Application Ref: H16-1191-25

Proposal: **Demolition of redundant commercial buildings and the erection of 5 dwellings**

Location: **39-41 Albert Street, Spalding, PE11 2LD**

PROPOSED BLOCK PLAN

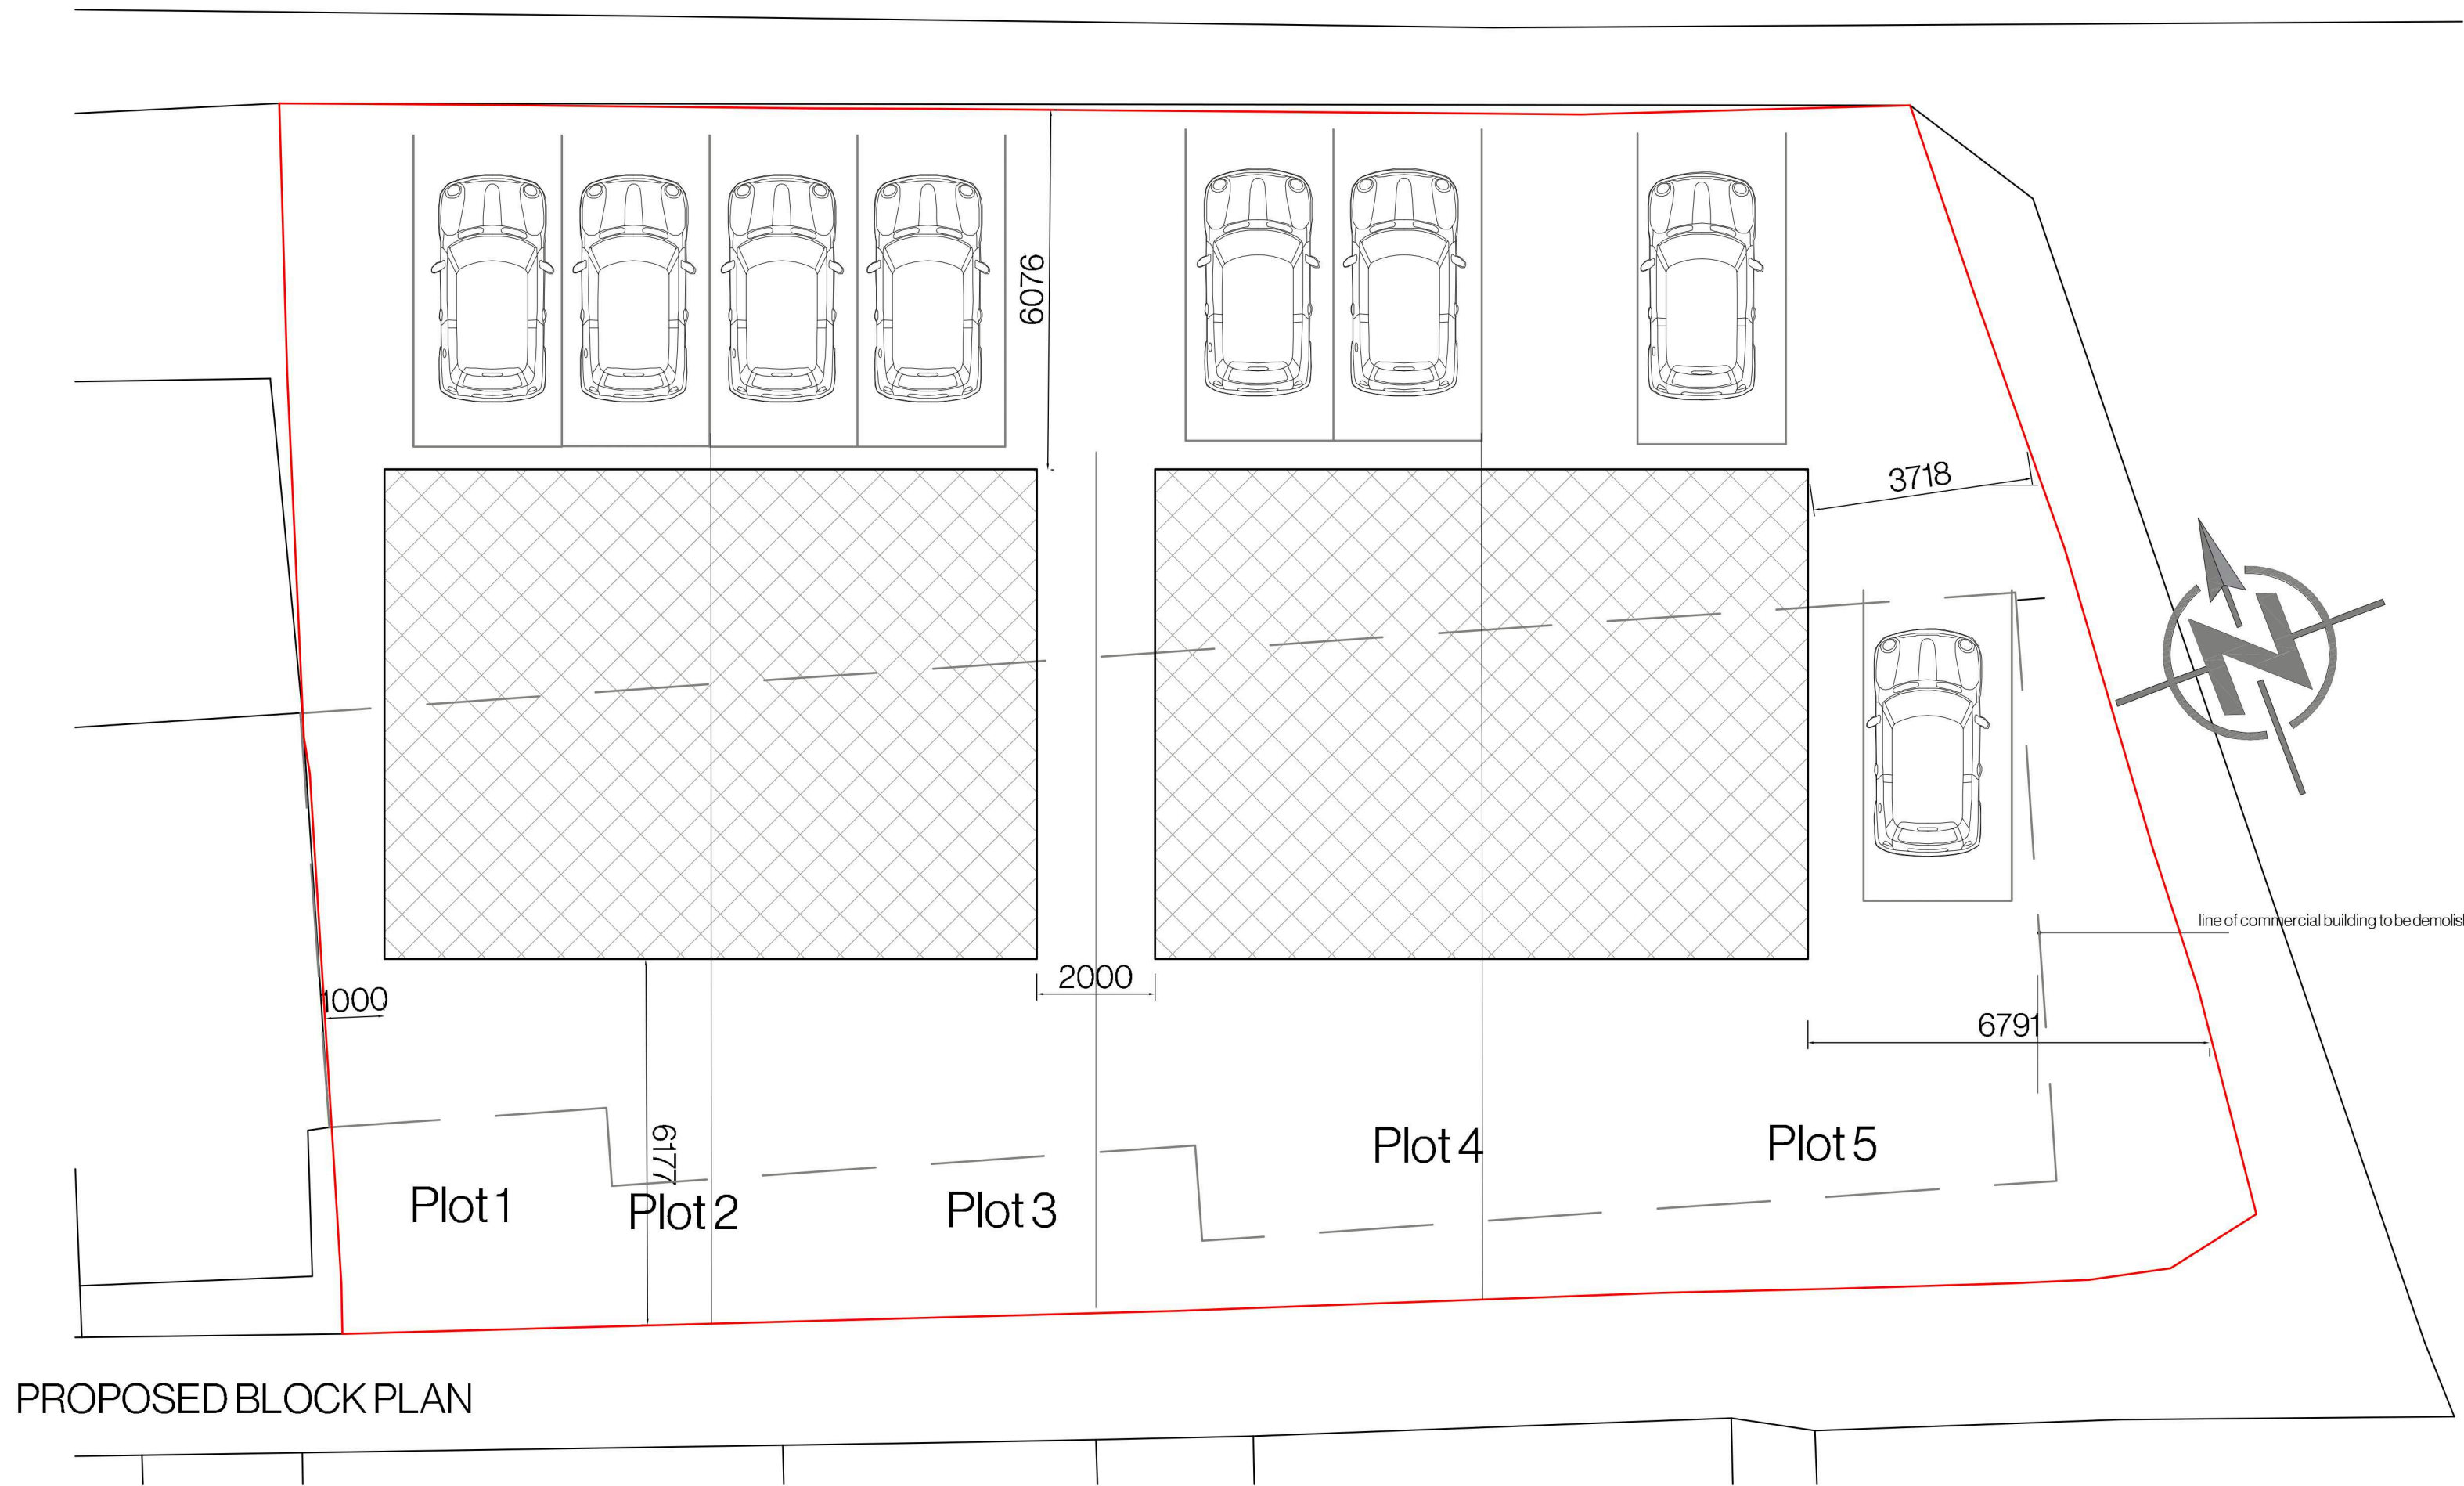
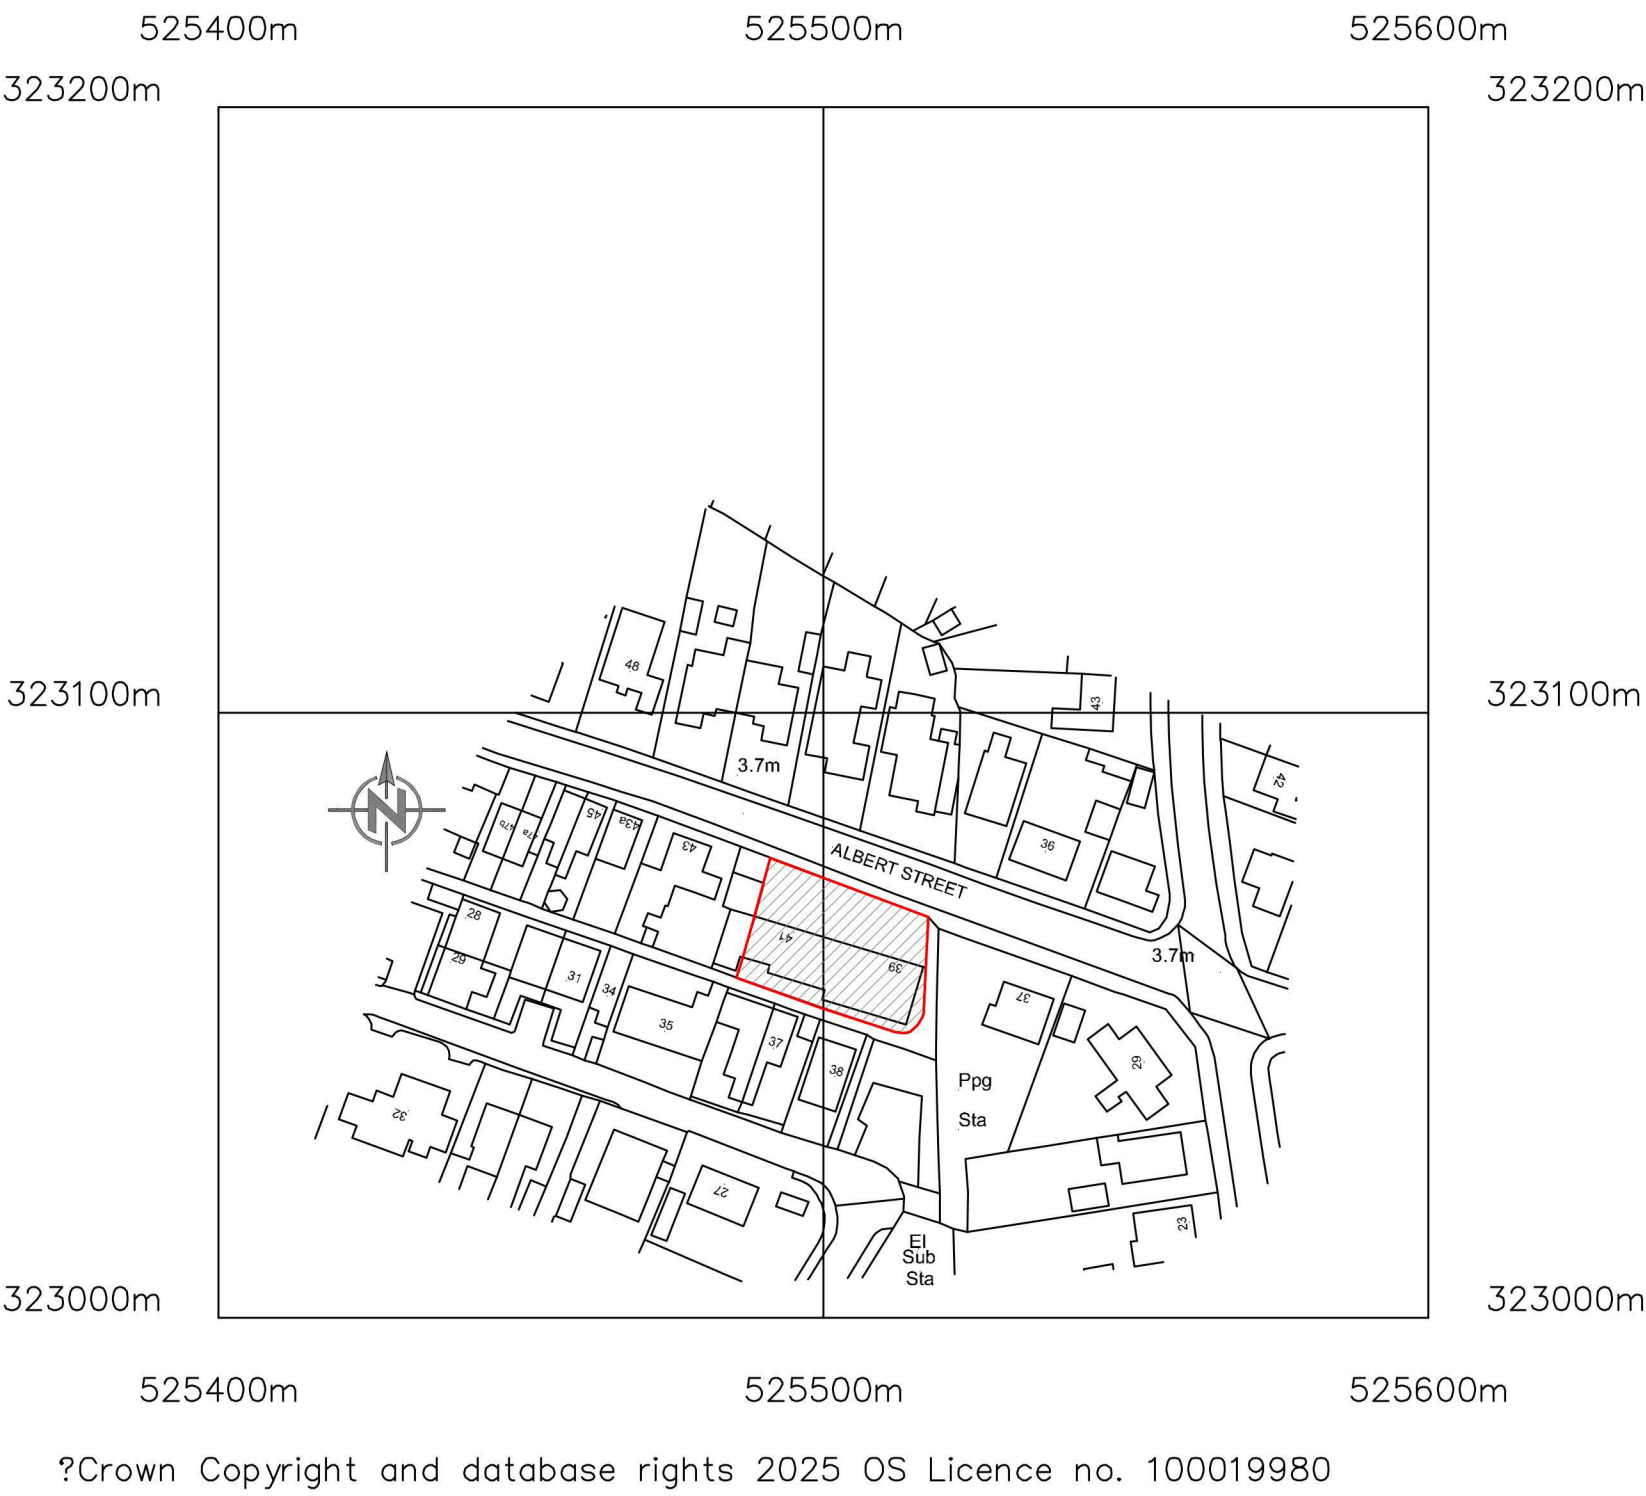
The whole of the frontage requires a dropped crossing – a note should be added to the proposed site plan to say it will be constructed to Lincolnshire County Council Specification.

The linear parking along the front should ideally be broken up with low level planting.

Secure cycle parking should be provided for each dwelling.

In accordance with the SELLP the parking for a 3-bed dwelling should be 2 spaces and for a 4-bed dwelling 3 spaces should be provided. You could argue that plots 4 and 5 could be a 4-bed dwelling as whilst it is noted that a room is a study it could be used as a bedroom.

Please include the dimensions of the parking spaces on the proposed site plan.
